**Addendum No. 1**

RE: Contract # C204838

**Edgecombe County (U-4424)**

NC-111 (WILSON ST) FROM US-64 ALT (WESTERN BLVD) TO NC-122 (MCNAIR RD) IN TARBORO.

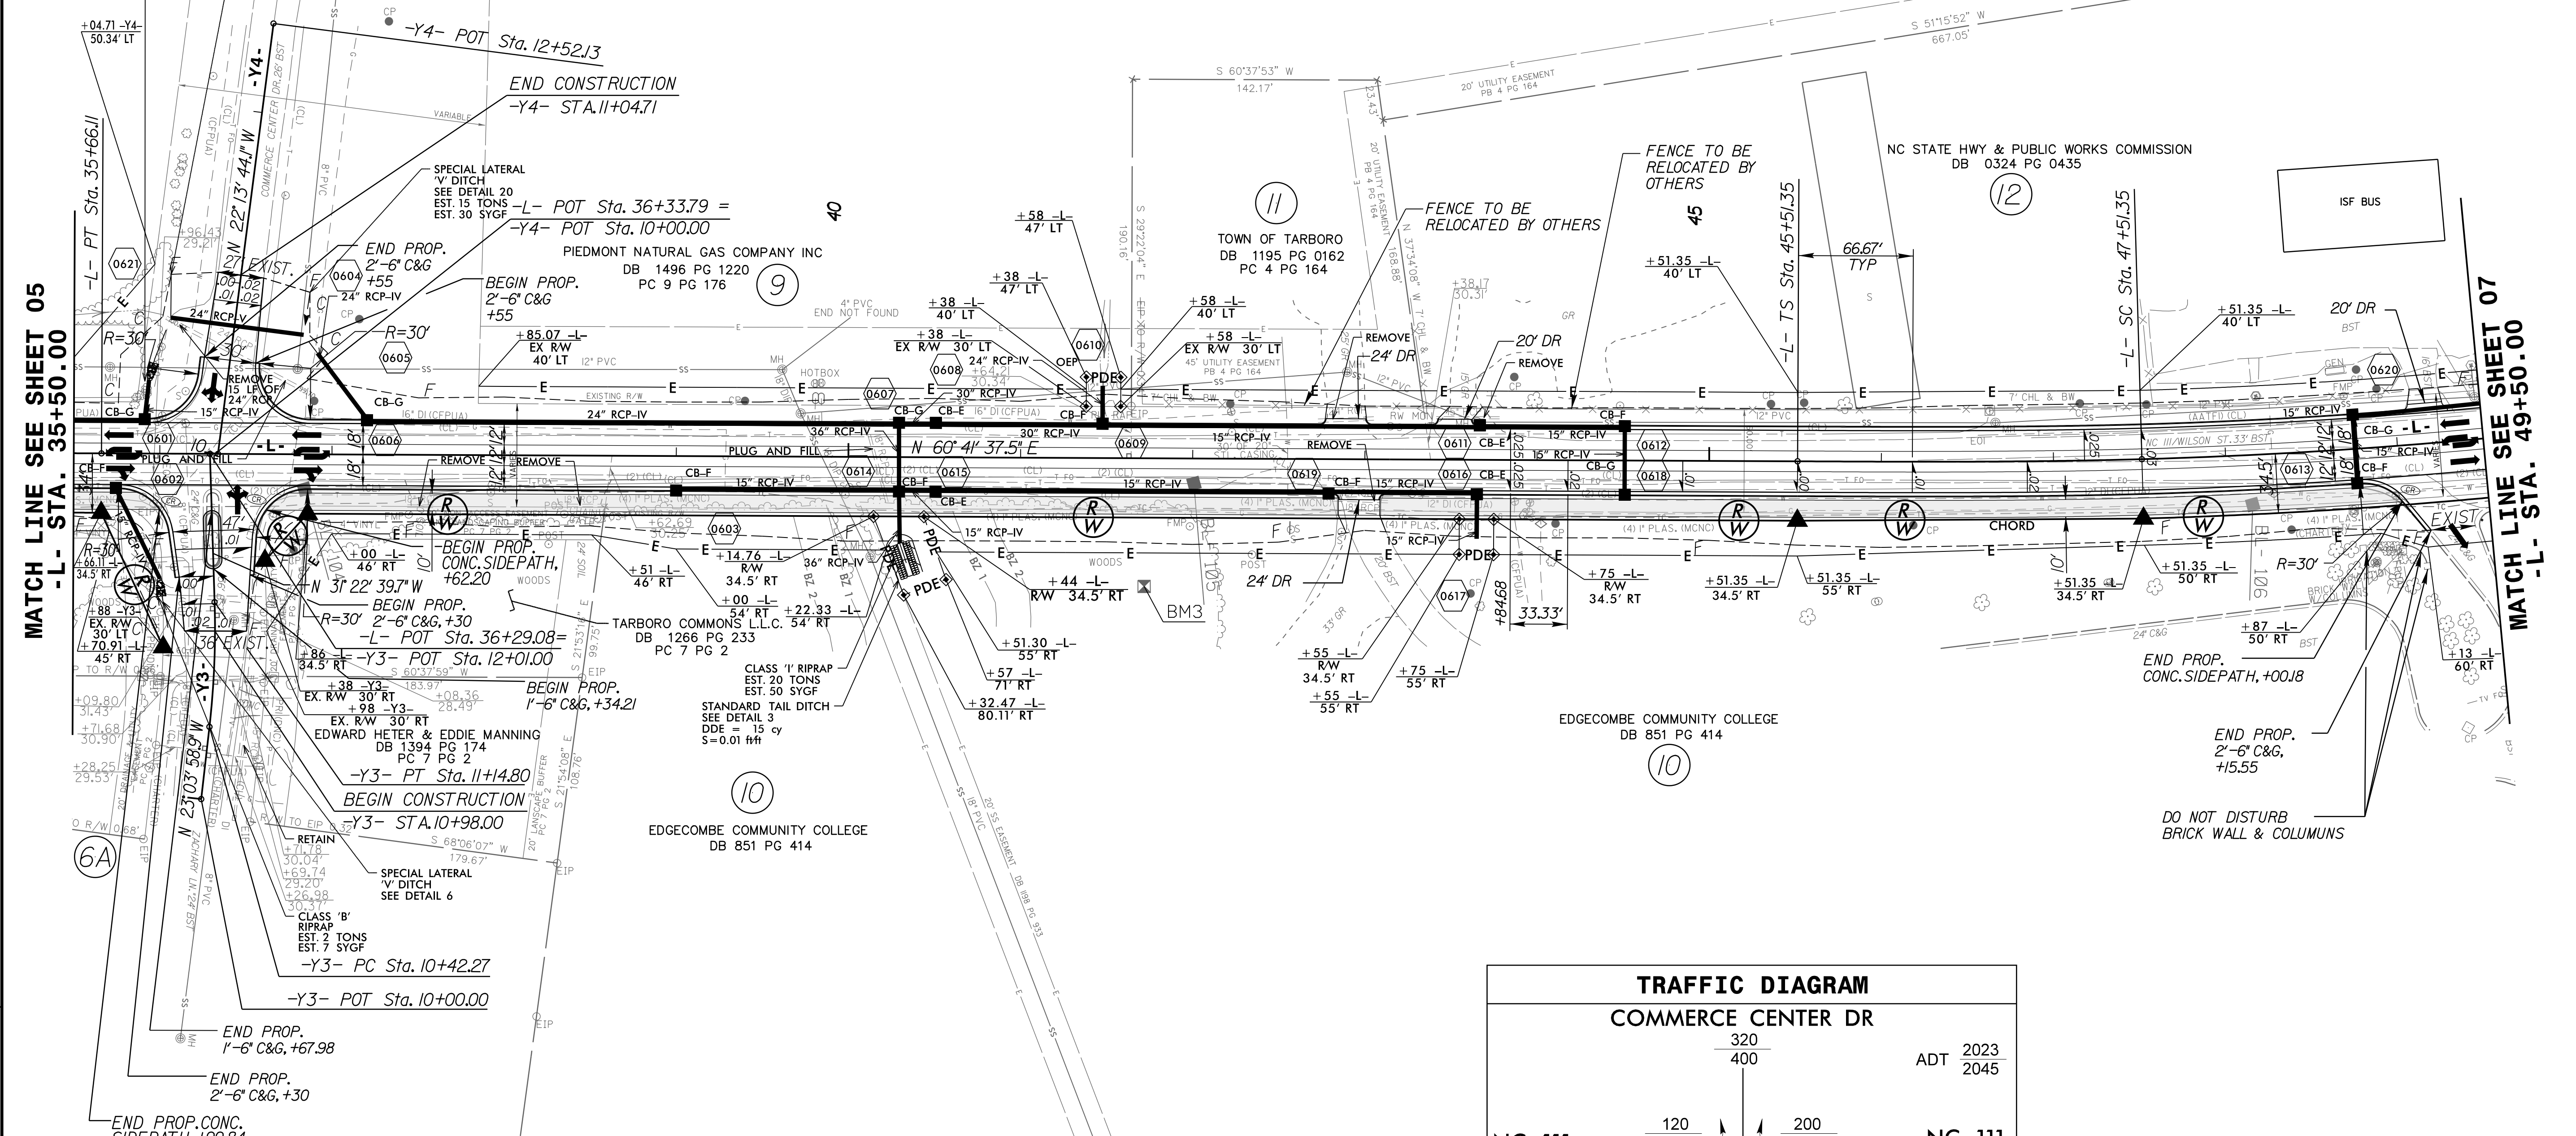
| Sheet No. | Revision                                                                            |
|-----------|-------------------------------------------------------------------------------------|
| 6-7       | Note added to clarify that fences on Parcels 11 & 12 are to be relocated by others. |

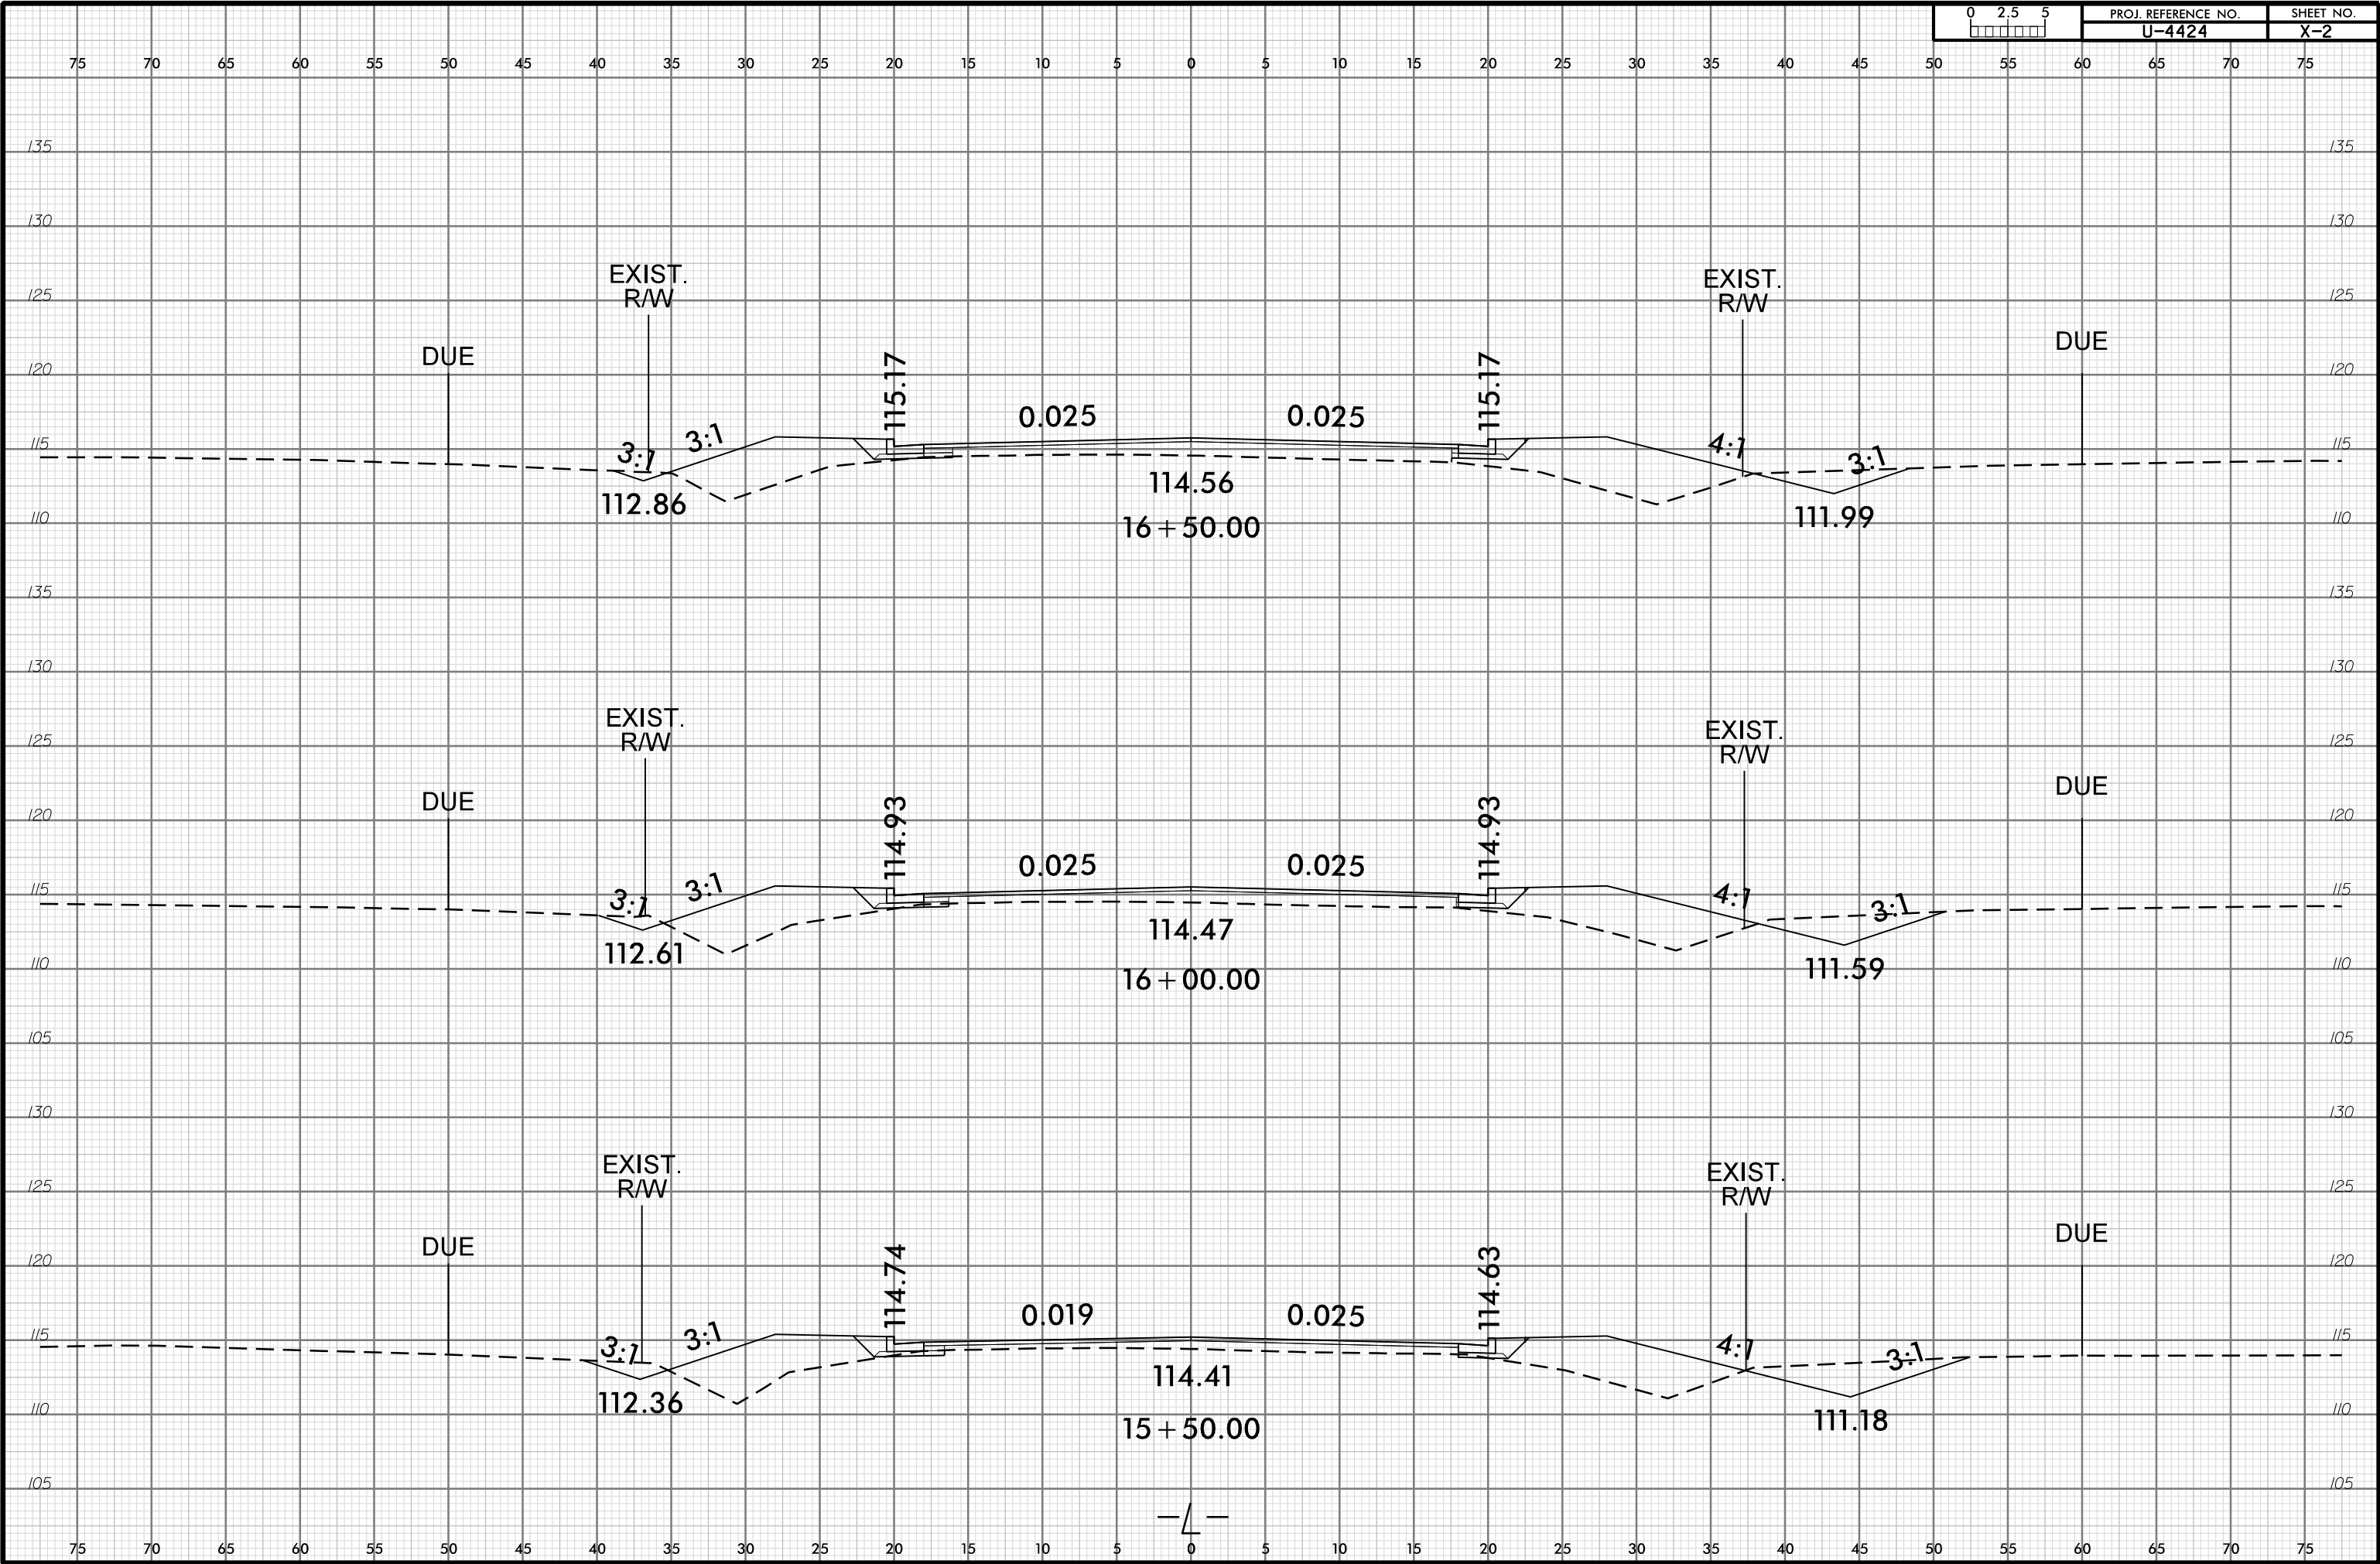
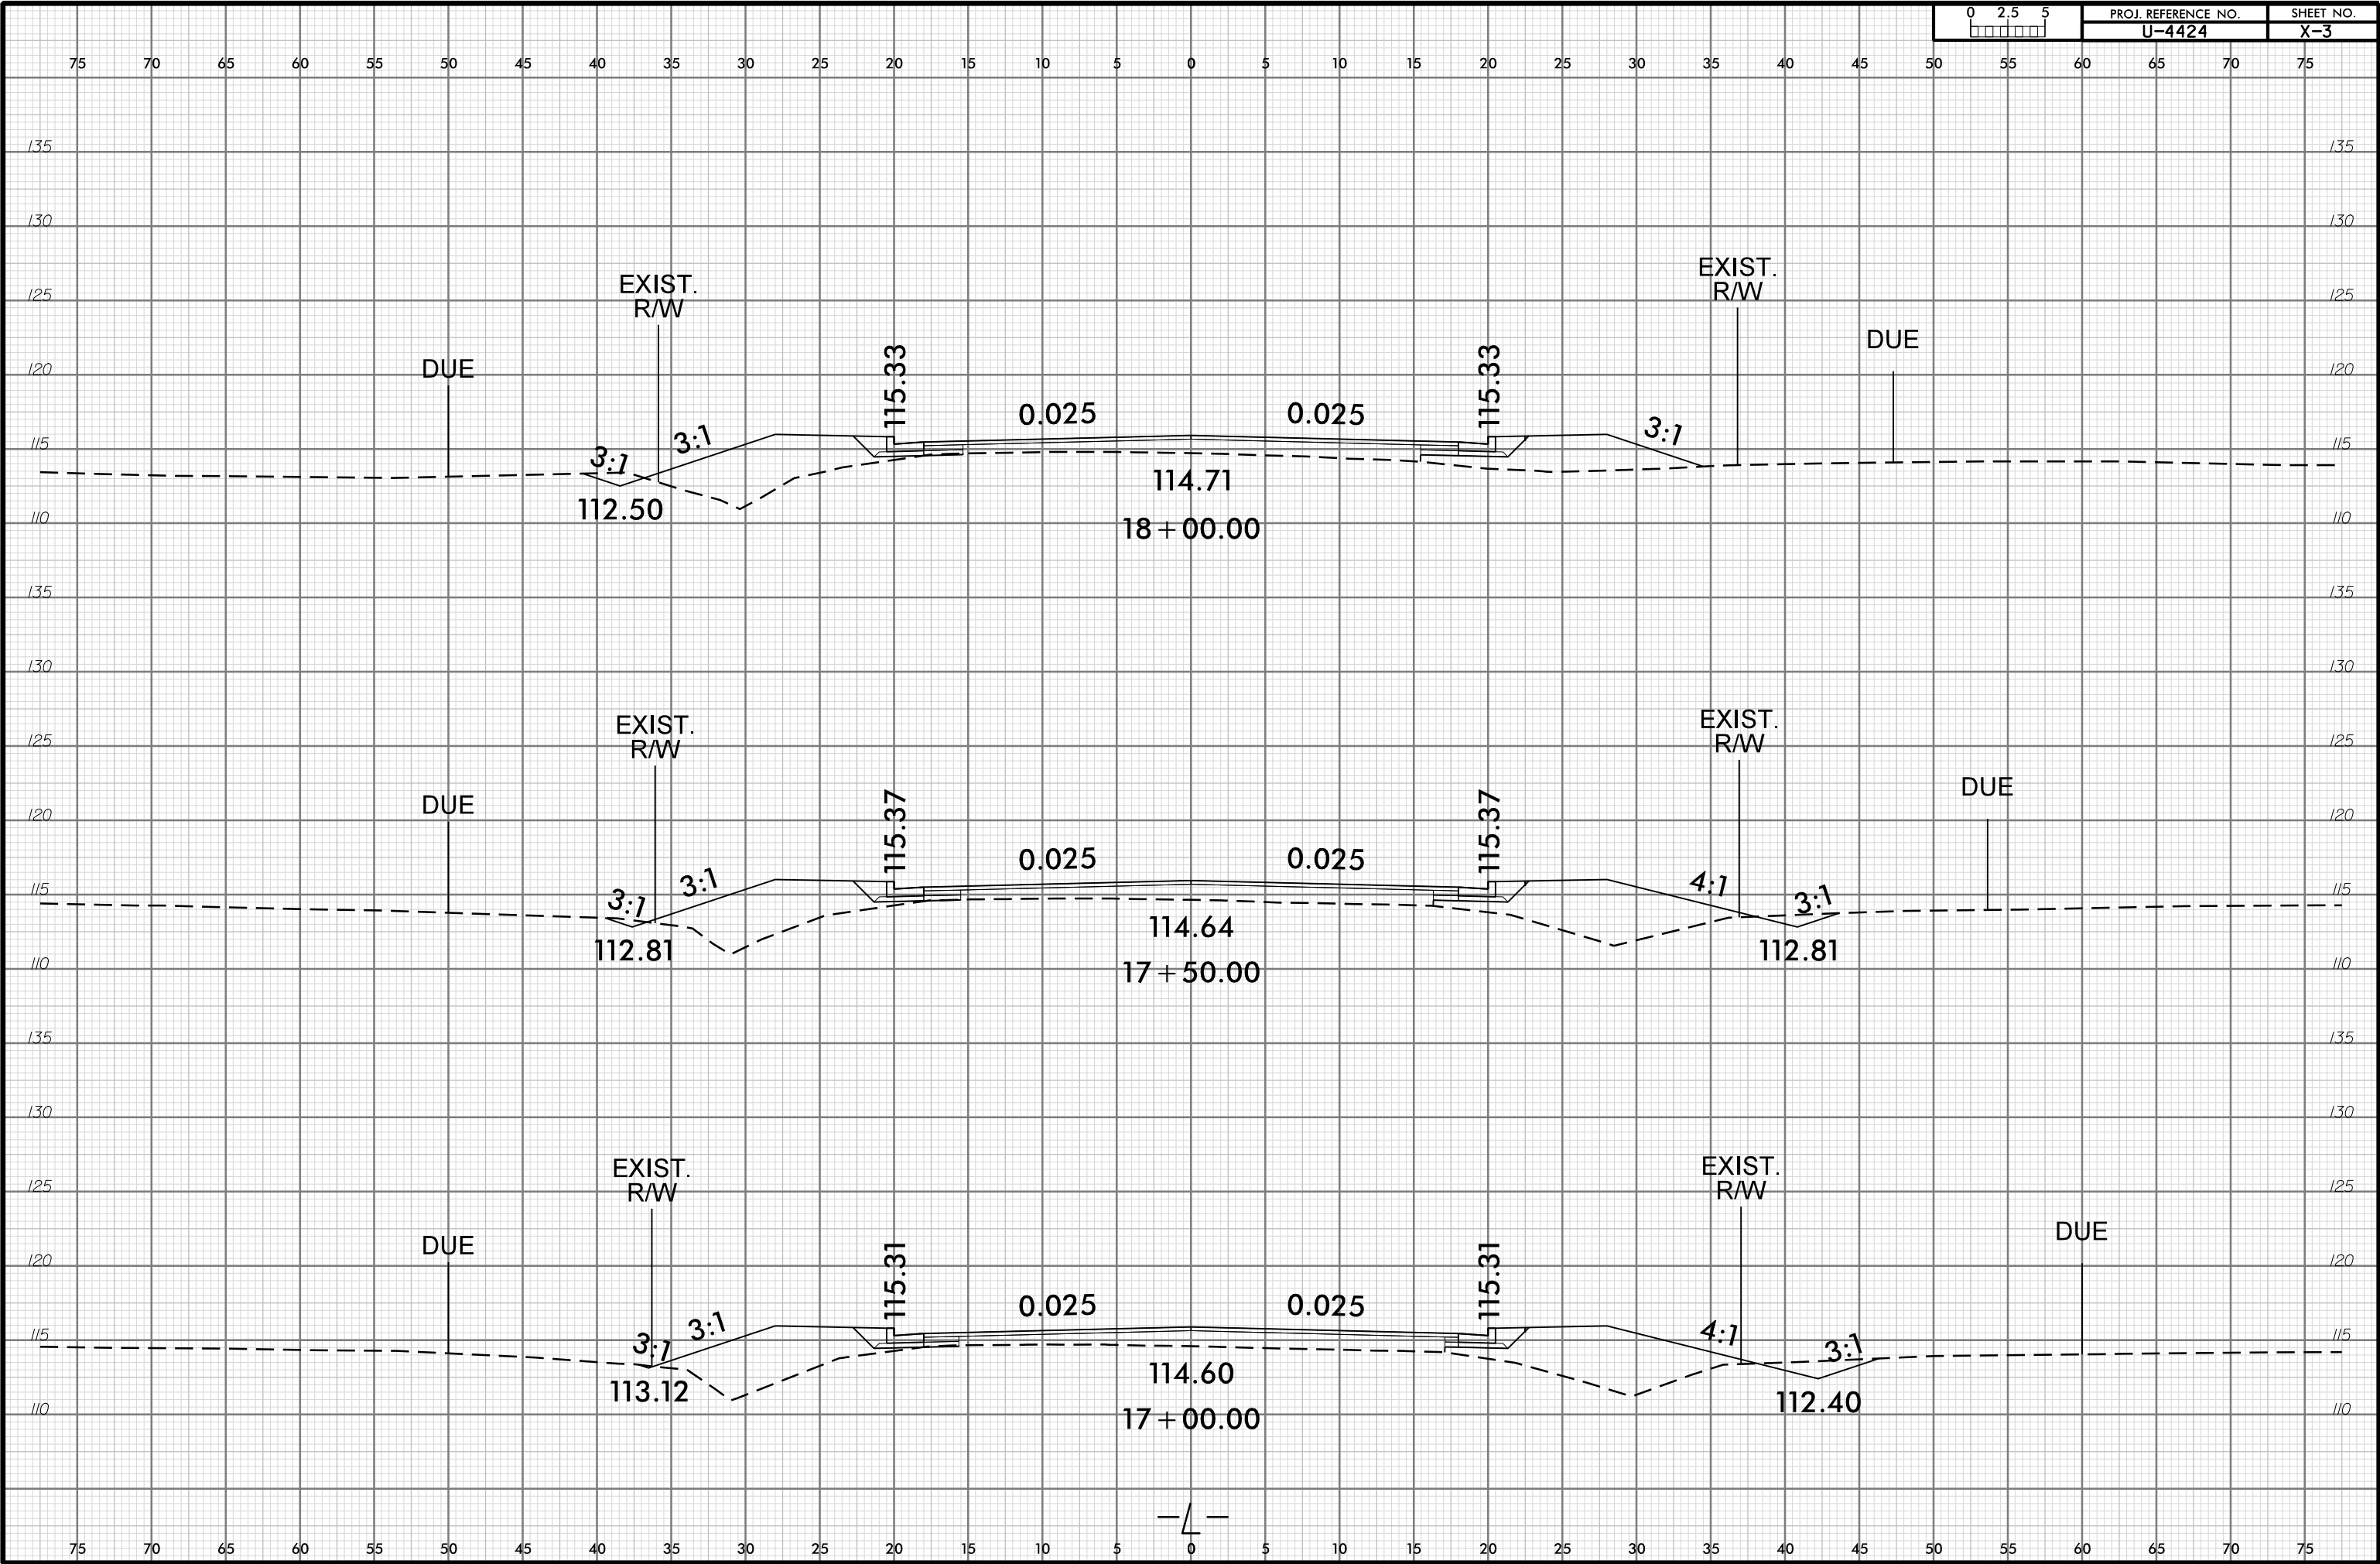
| Sheet No.     | Revision                                    |
|---------------|---------------------------------------------|
| X-1A          | Earthwork volume revised.                   |
| X-1 thru X-72 | Wedging limits along -L- alignment revised. |
